23 September, 2015

**Re: Swire Cold Storage Facility, Marsden Park, Blacktown LGA (SSD 6799) – Notice of Exhibition (Part Lot 4 in DP 1198299)**

TransGrid has reviewed this proposed development as outlined in the Notice of Exhibition and is willing to grant conditional consent to the proposed encroachment of our easement being State significant infrastructure, subject to the following terms and conditions and includes advice from TransGrid's electrical engineers:

Title:	SITE PLAN SHOWING TRANSGRID CABLES
--------	---------------------------------------

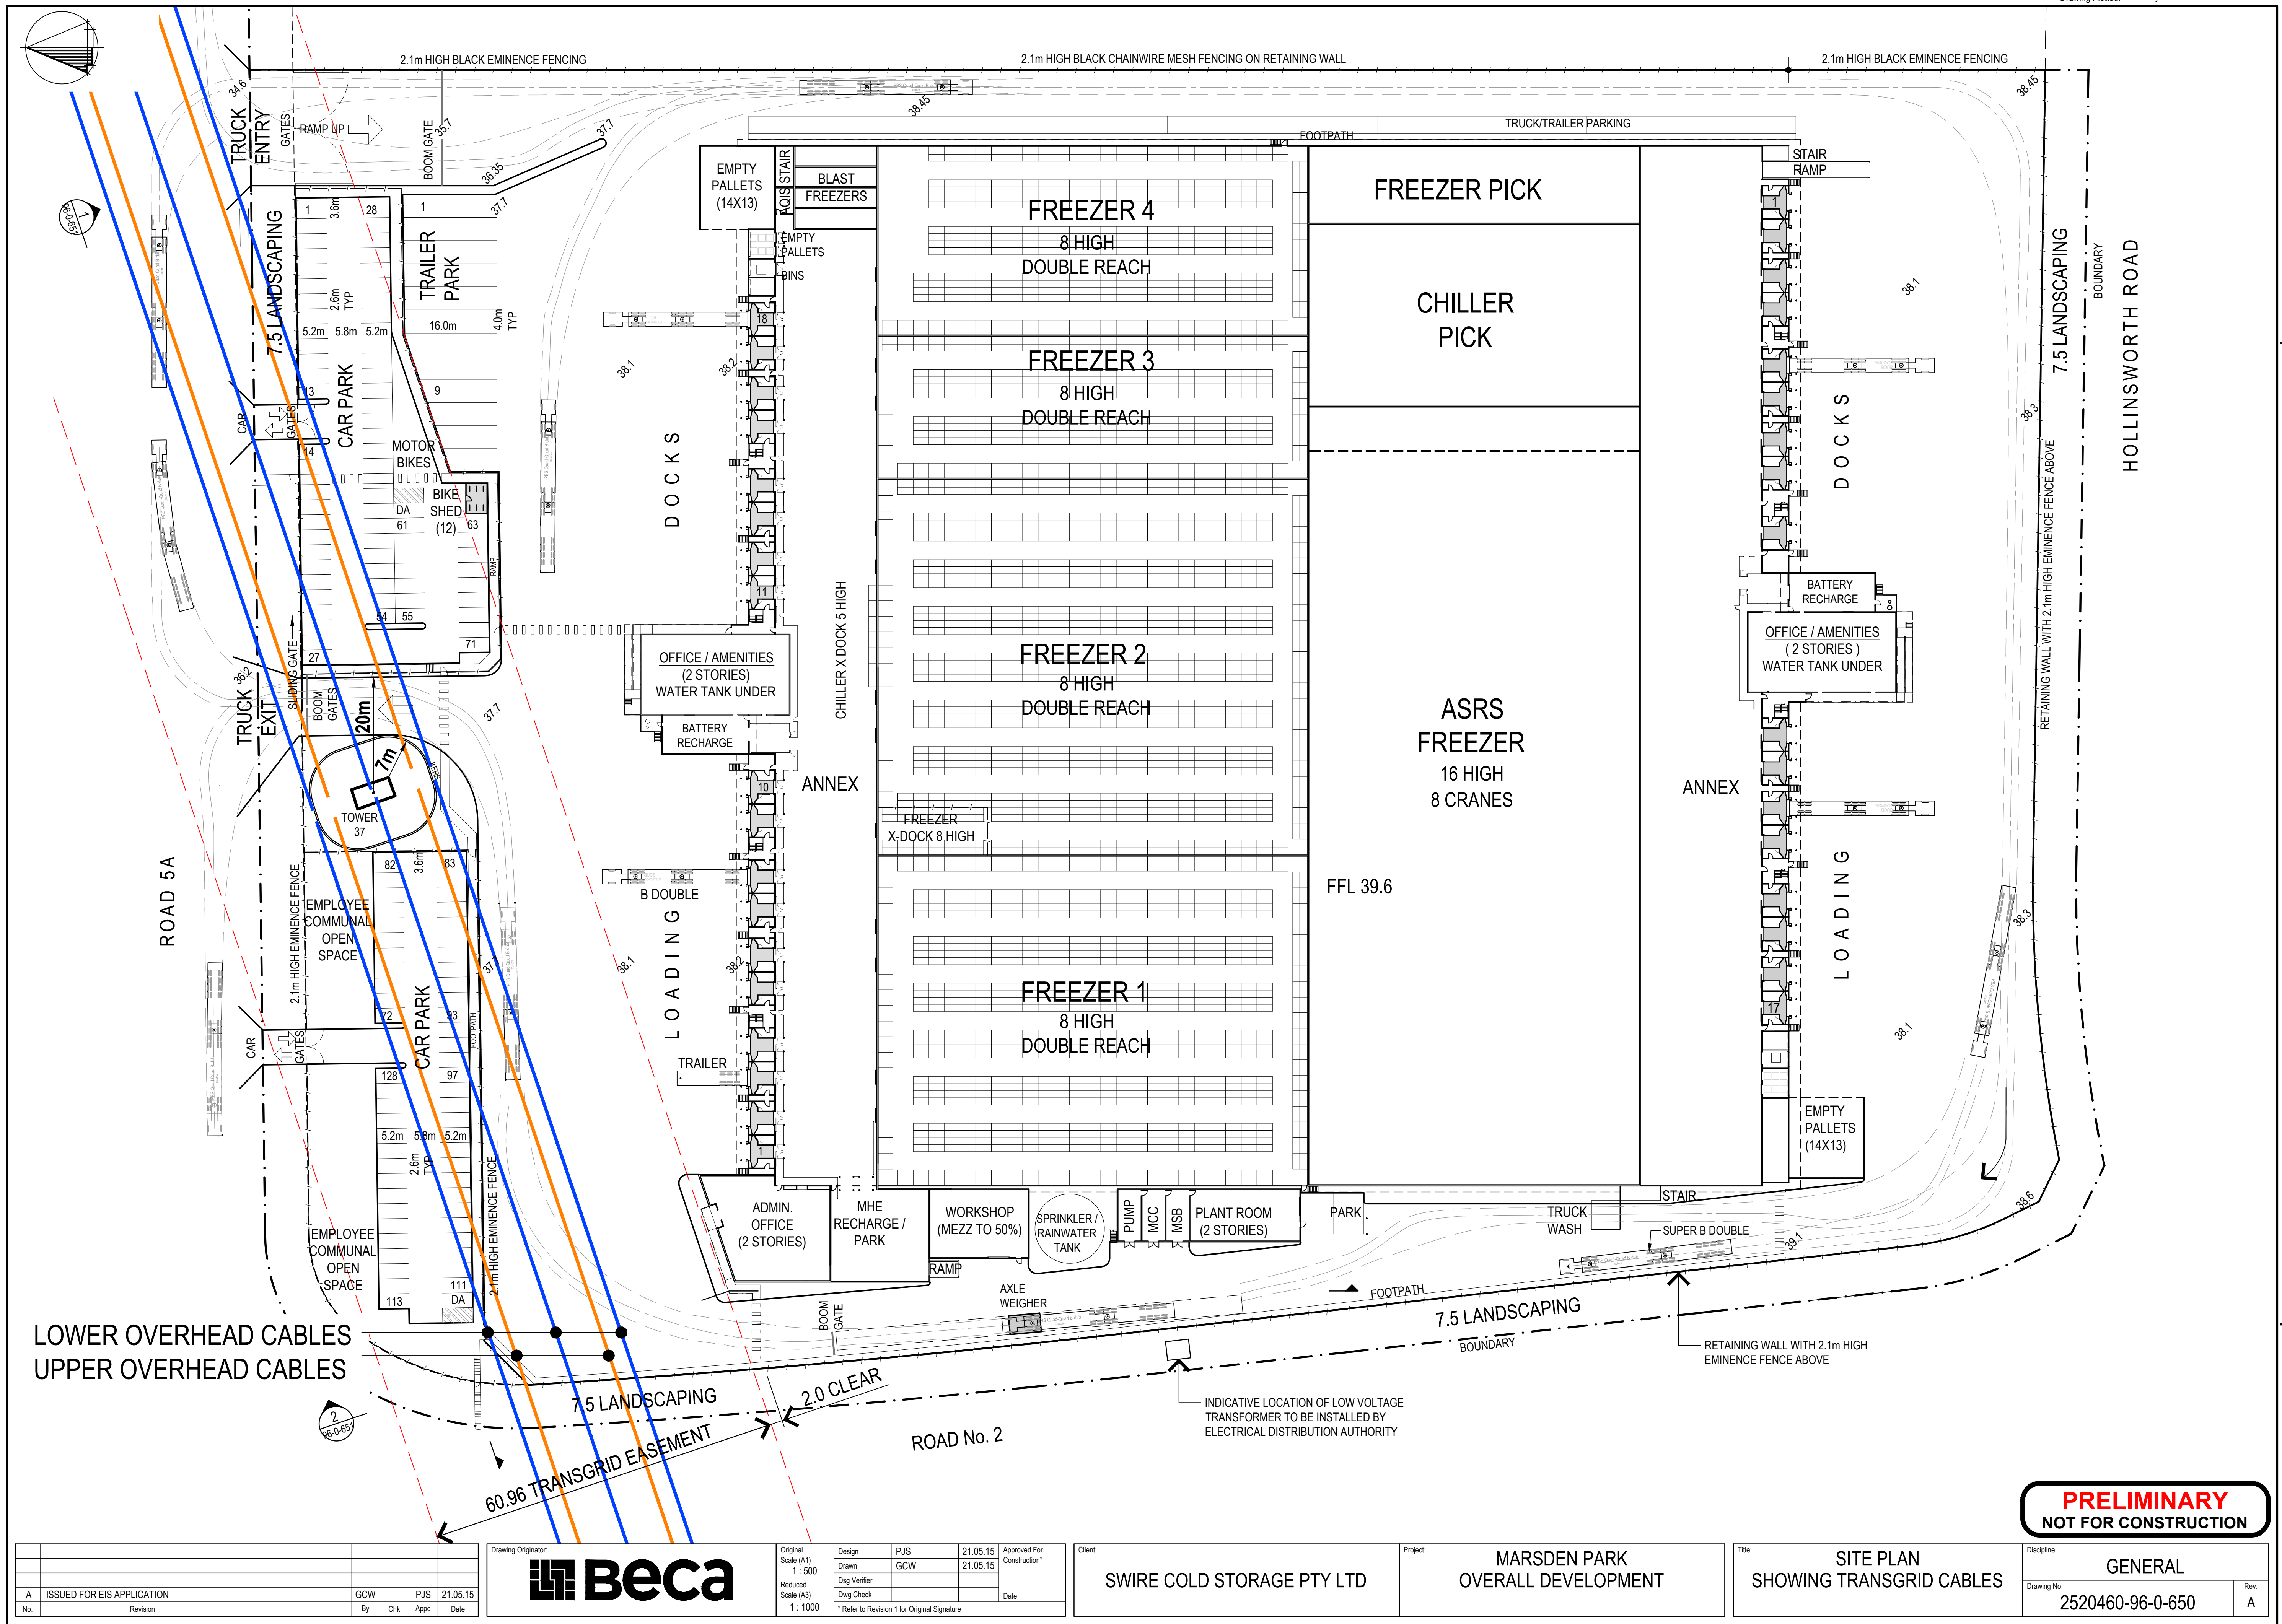
- 2) Referring to Drawing 650 (Site Overview), TransGrid's use and access to the transmission line easement must be preserved and provided at all times. This is an essential condition of consent and TransGrid will refuse access to parts of the easement from time to time in order to undertake essential works to our high voltage infrastructure and this includes the truck exit situated immediately adjacent to the stanchion.

During times when the Truck Exit is closed for TransGrid service of the transmission line, egress will only be possible using the Truck Entrance. TransGrid will require a set of keys to the property security and boom gates be provided to ensure we are able to access our easement and stanchion at any time.

Title:
CONCEPT
UTILITIES WITHIN TRANSGRID
EASEMENT

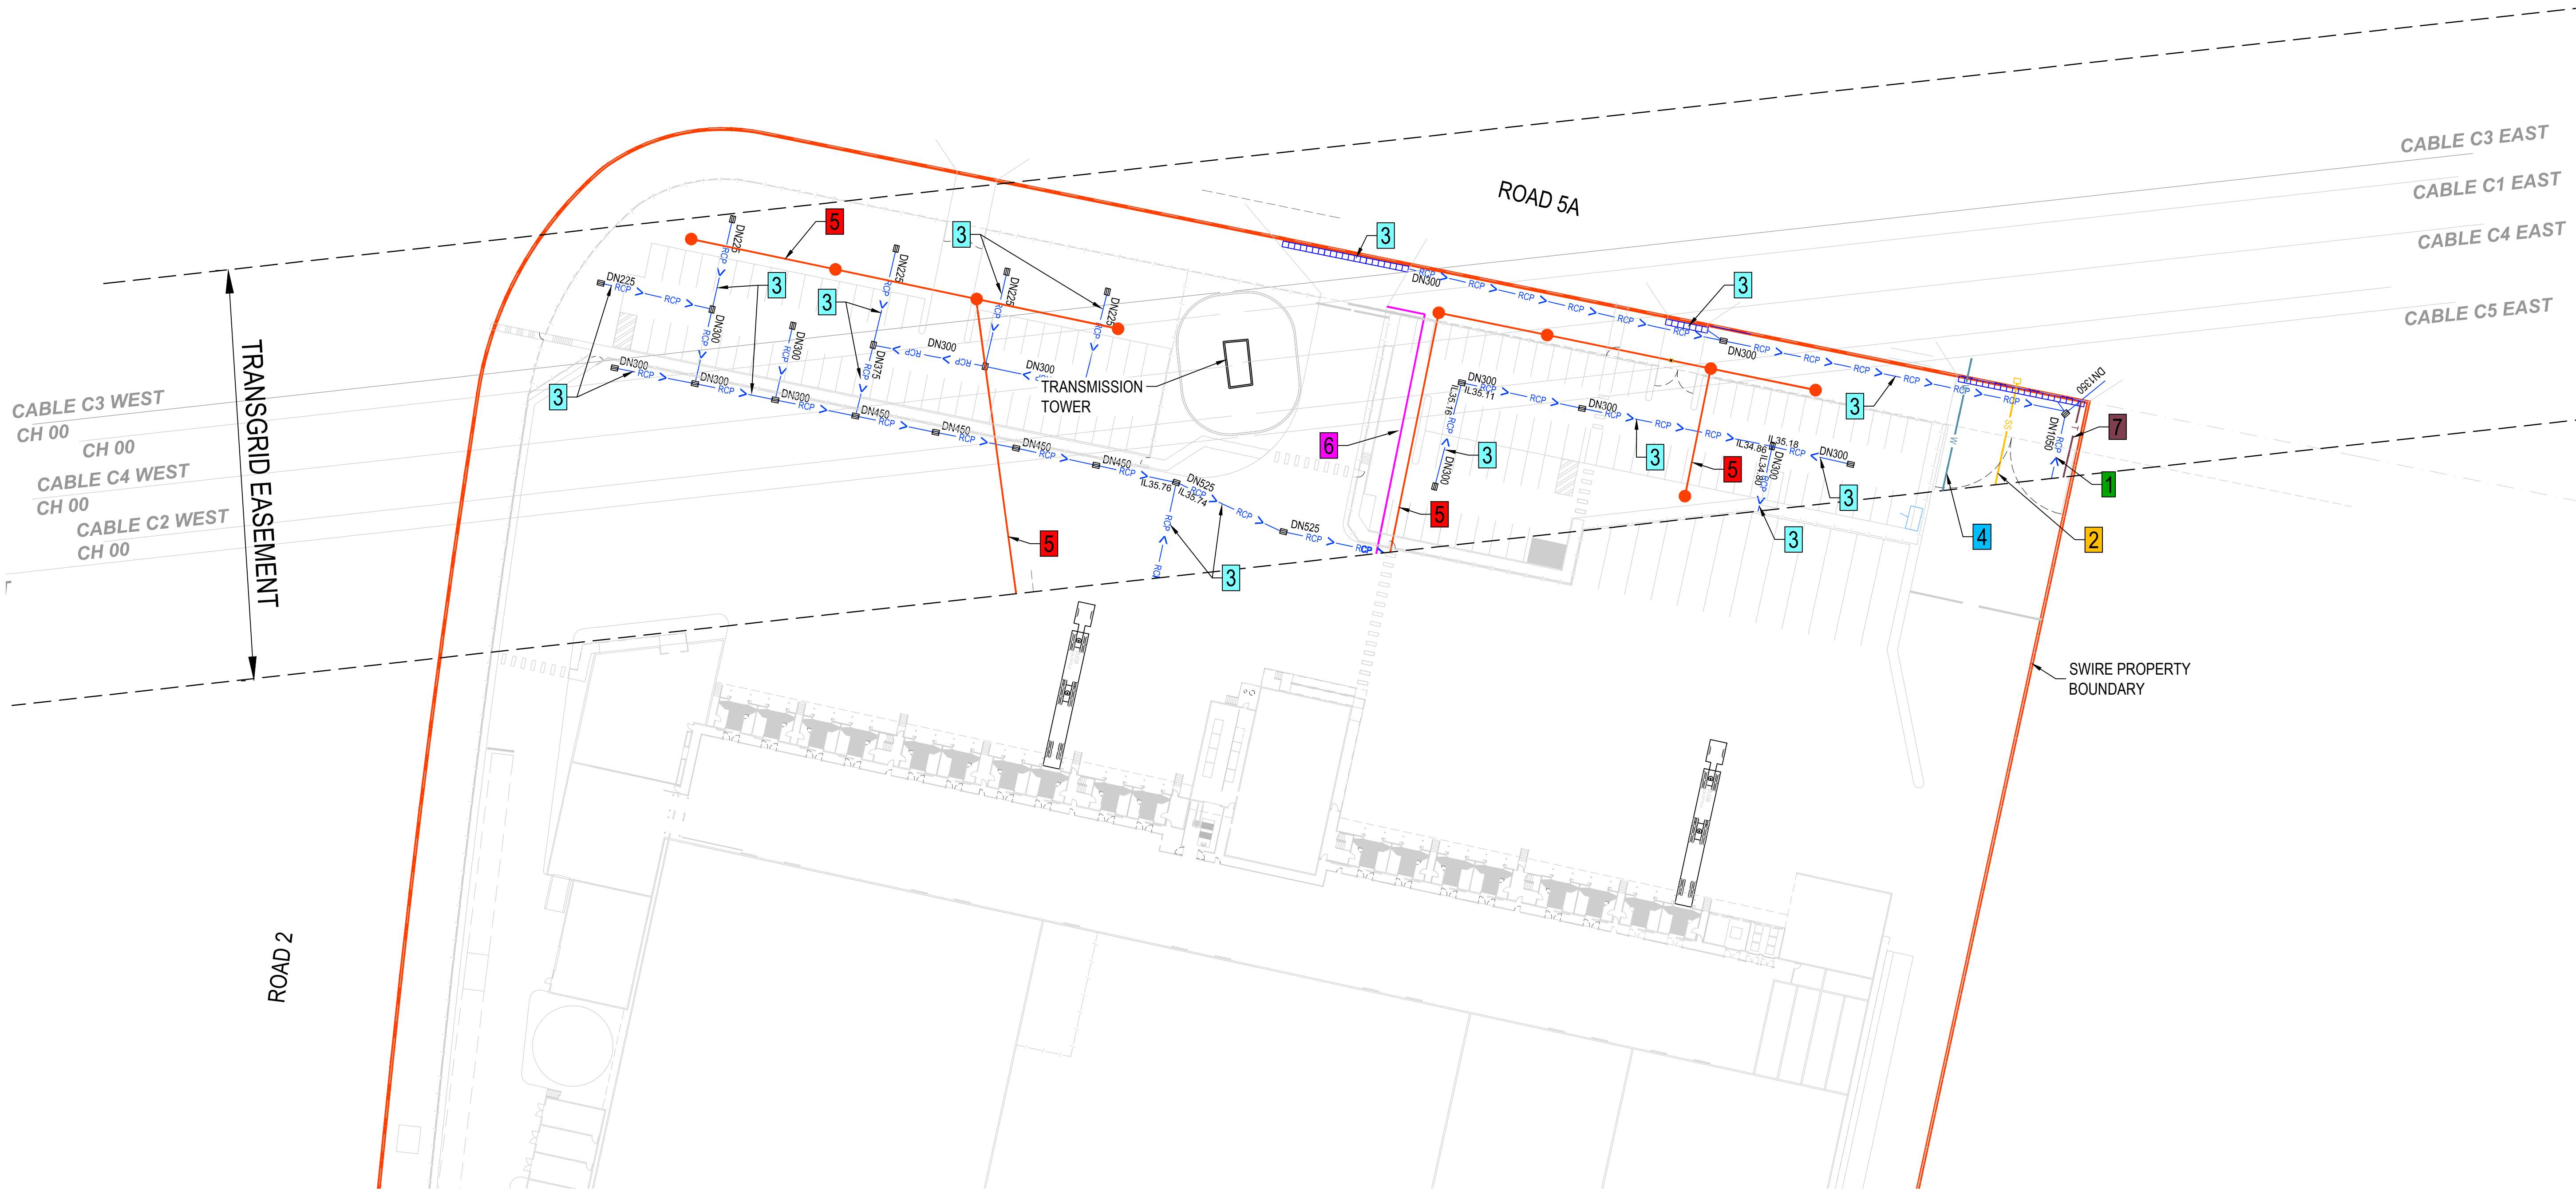
- 4) Referring to Drawing 653 (Utilities and carpark lighting), there are vertical and horizontal clearance concerns regarding the proposed overhead lantern lighting in the car parking areas. Further, on account of the already constrained access to our easement and stanchion on the subject site arising from the proposed development, the light poles must be removed. This is to preserve unobstructed access for TransGrid to be able to operate large mobile plant and equipment on the easement, including cranes and elevated work platforms with out-riggers etc, pursuant to the WorkCover NSW 'Work Near Overhead Power Lines' Code of Practice 2006. Lighting for the car parking areas should be positioned off the facing side of the proposed warehouse.
